WEST SUSSEX COUNTY COUNCIL CONSULTATION

TO:	Arun District Council FAO: Anita Gardner
FROM:	WSCC - Highways Authority
DATE:	29 July 2020
LOCATION:	74-76 Canada Road Arundel BN18 9HY
SUBJECT:	AB/63/20/DOC Approval of details reserved by condition imposed under ref AB/60/17/PL relating to Condition Nos 3 - materials & finishes, 4 - site set up, 7 - vehicular access onto Canada Road, 8 - vehicular access and 9 - surface water drainage.
DATE OF SITE VISIT:	n/a
RECOMMENDATION:	Modification
S106 CONTRIBUTION TOTAL:	n/a

Development Layout 1:200

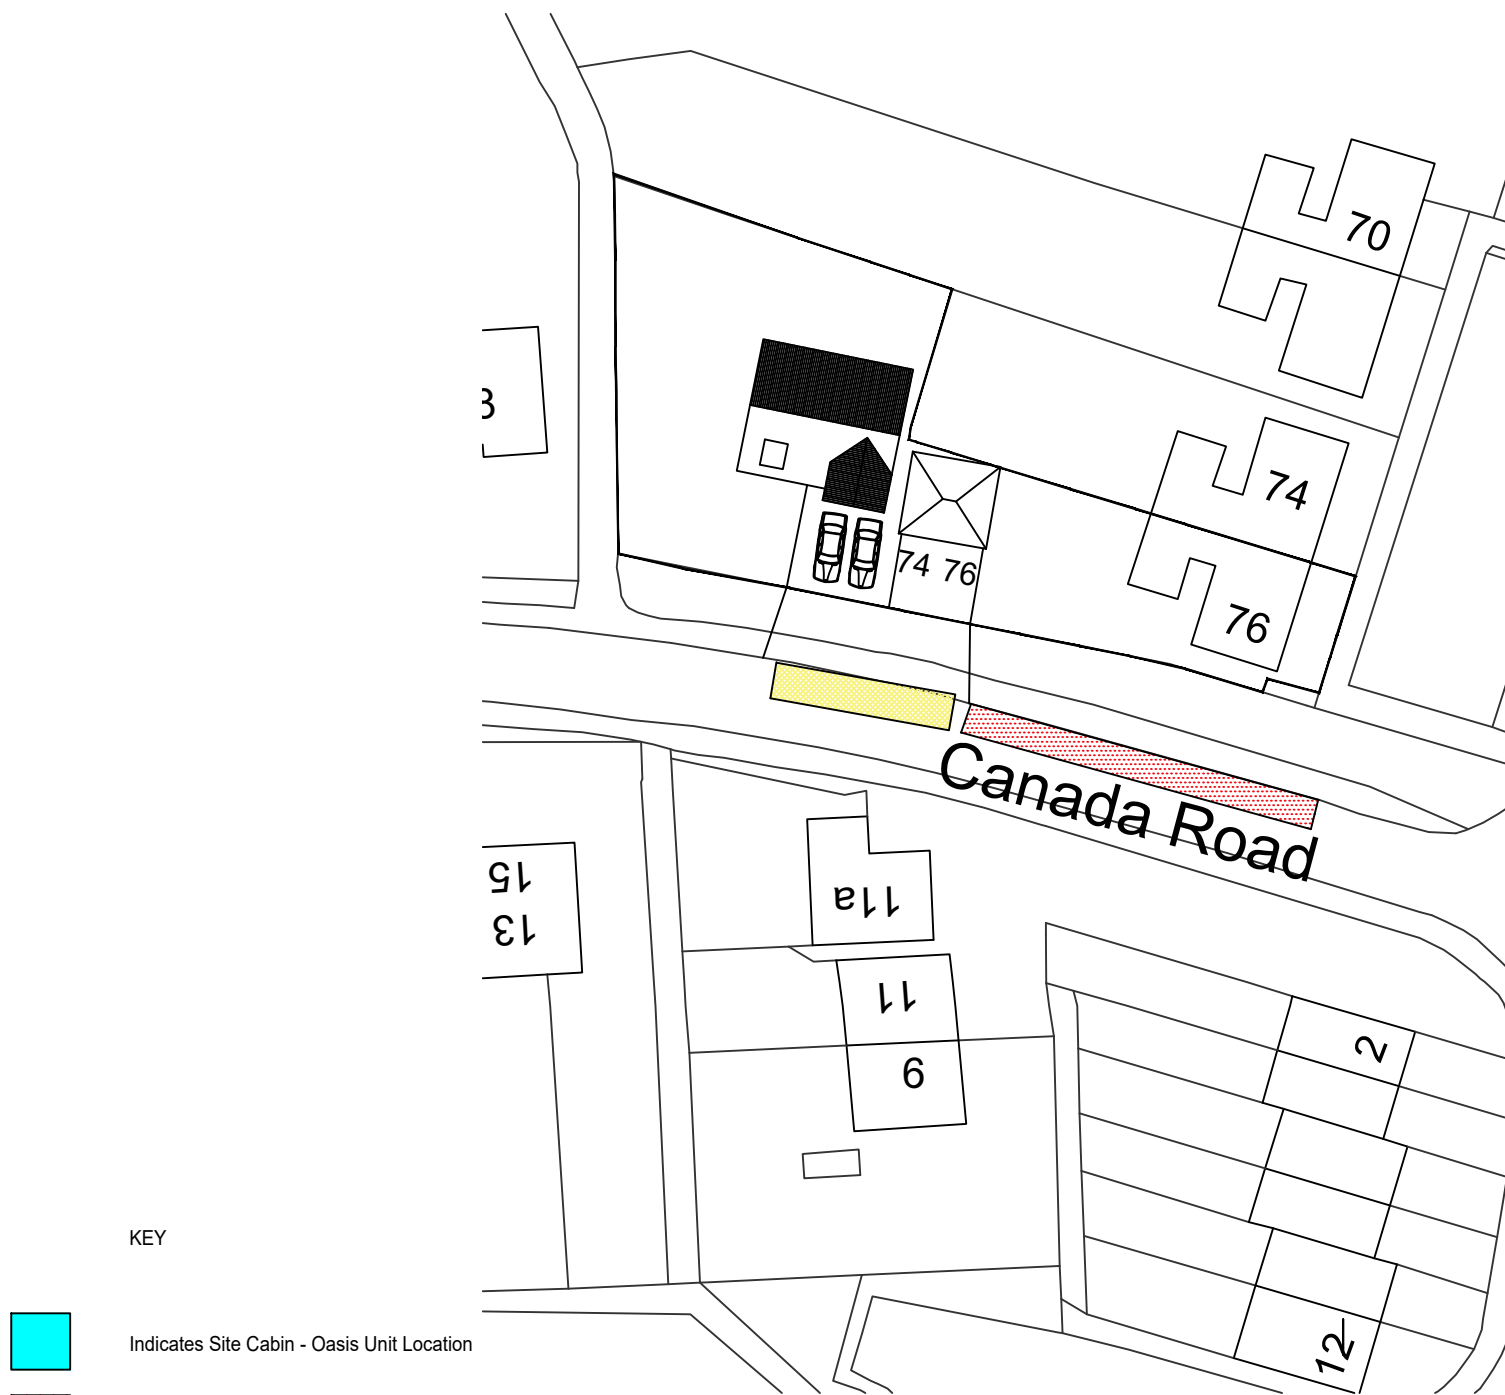
It is noted that the plan is annotated to demonstrate a 13.8 metre VCO. The LHA provide the following comments

The Local Planning Authority and the applicant should be mindful that the WSCC Highways Area Office, who is responsible for the issuing of VCO Licenses, do not wish to see VCO's measuring over 6.4 metres in this location due to the existing parking pressures and the loss of on-street parking provision for neighbouring residents. While this is not a highways safety issue the LHA wish that good planning practices are kept and as such, no planning application is permitted where it cannot be implemented. As a result, the LHA advises the applicant to reduce the VCO to 6.4 metres maximum.

The LHA requests the applicant modifies the plans to reflect the above comments.

Development Layout 1:200

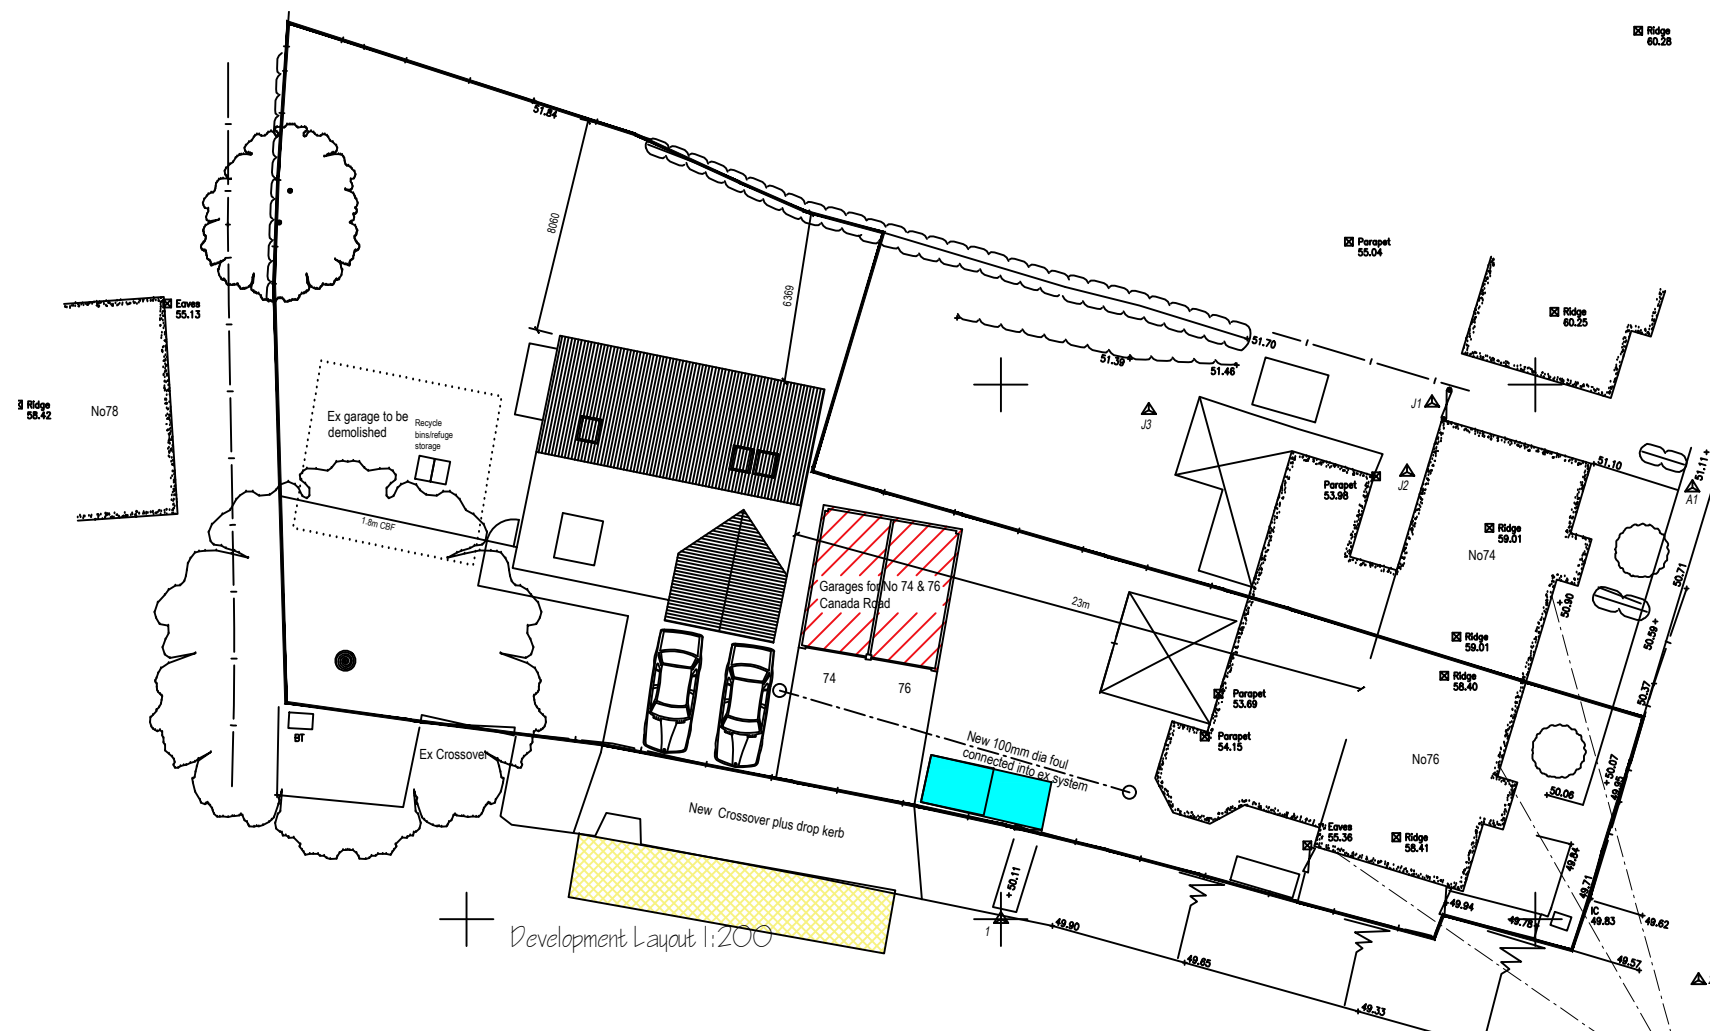
The applicant proposes to close the existing access, returning it to its existing status. The LHA are happy with these details.
